City of Albuquerque

DESIGN HYDROLOGY SECTION
123 Central NW, Albuquerque, NM 87102
(505) 766-7644

June 19, 1984

REF: OFFICE AND WAREHOUSE SITE (WESTERN MOST 110' OF TRACT 340 A2A1A)
H13-D13 5/15/84

DRAINAGE / GRADING PLAN
OFFICE & WAREHOUSE SITE
ZEARING AVENUE N.W.

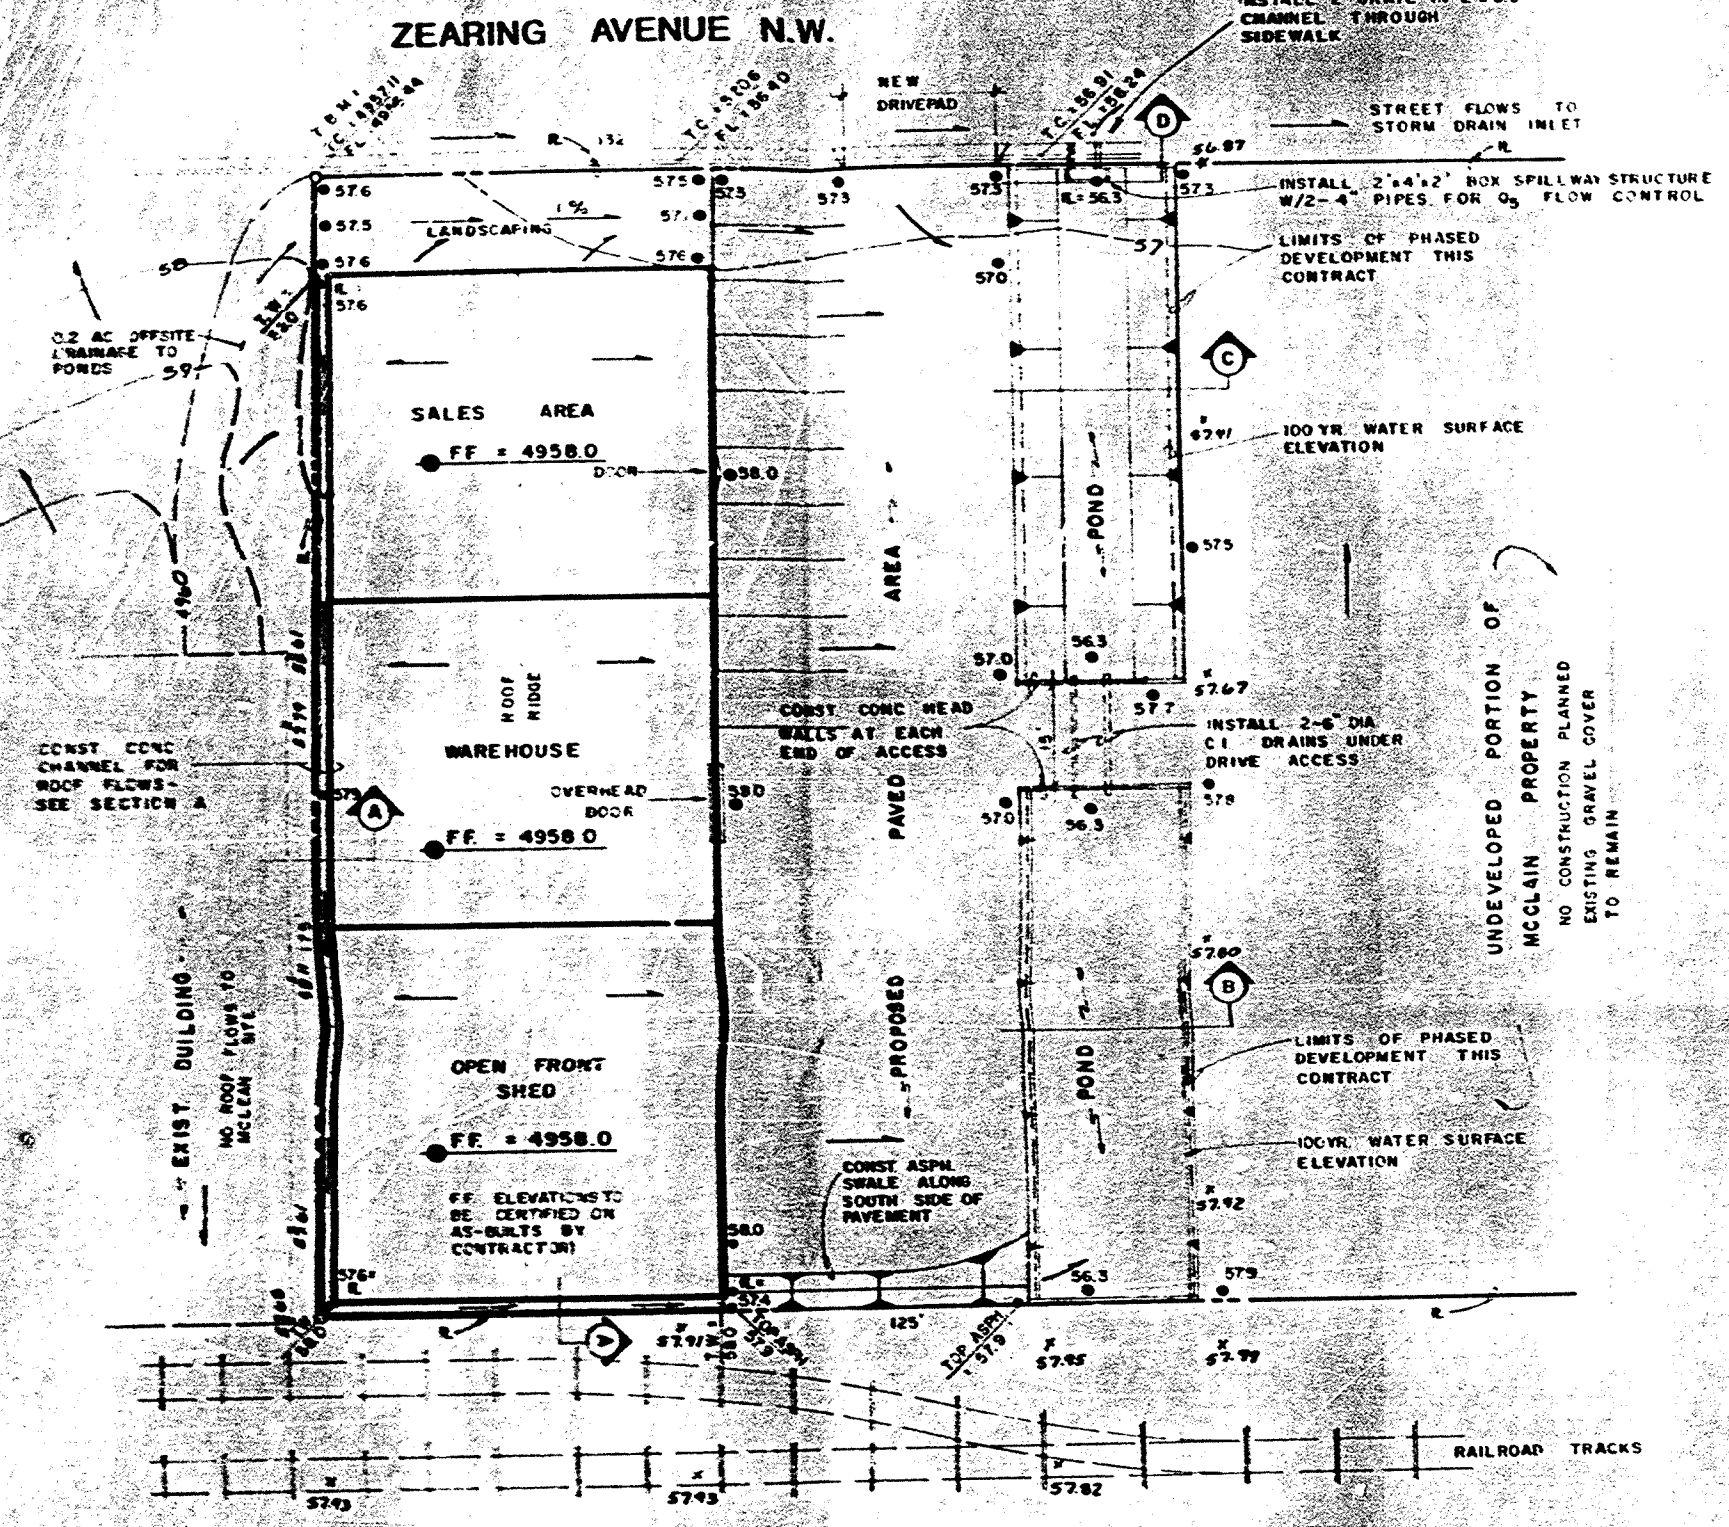
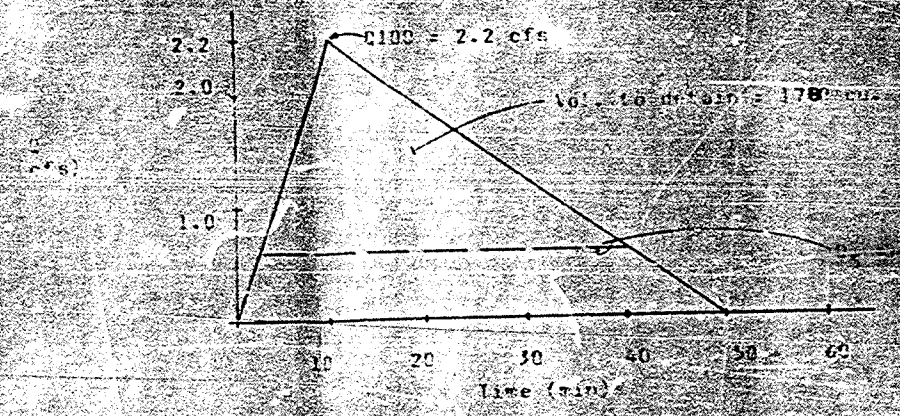
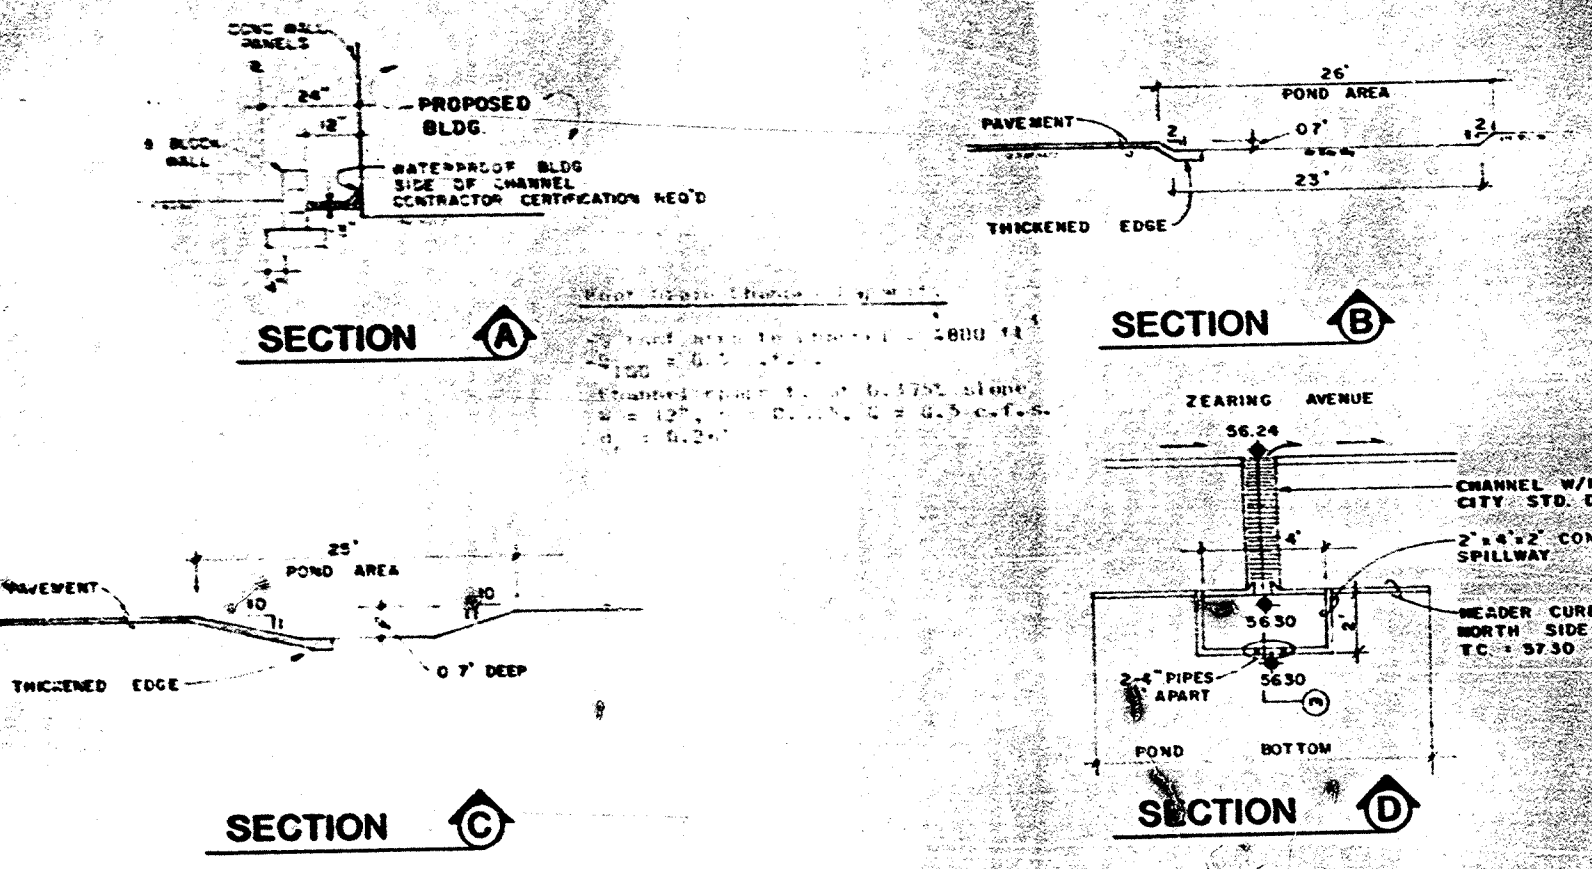
1. Complete information sheet designating resubmittal.
2. Professional's stamp with signature and resubmittal date.
3. Please include all pond calculations with your resubmittal.
4. Please identify the 100 year water surface elevation outlined and indicated on plan.
5. Spillway overflow must be routed through an approved curb cut, overflow is not allowed to drain across a public sidewalk.
6. Please address any off-site flows if any.
7. What impact will the undeveloped portion of the site have on the proposed development. If the undeveloped portion is disturbed from its natural state, an erosion control plan will be required.
8. Certification of west side of building for water proofing will be required.

9. Certification of finish floor elevation per required elevation will b. required.
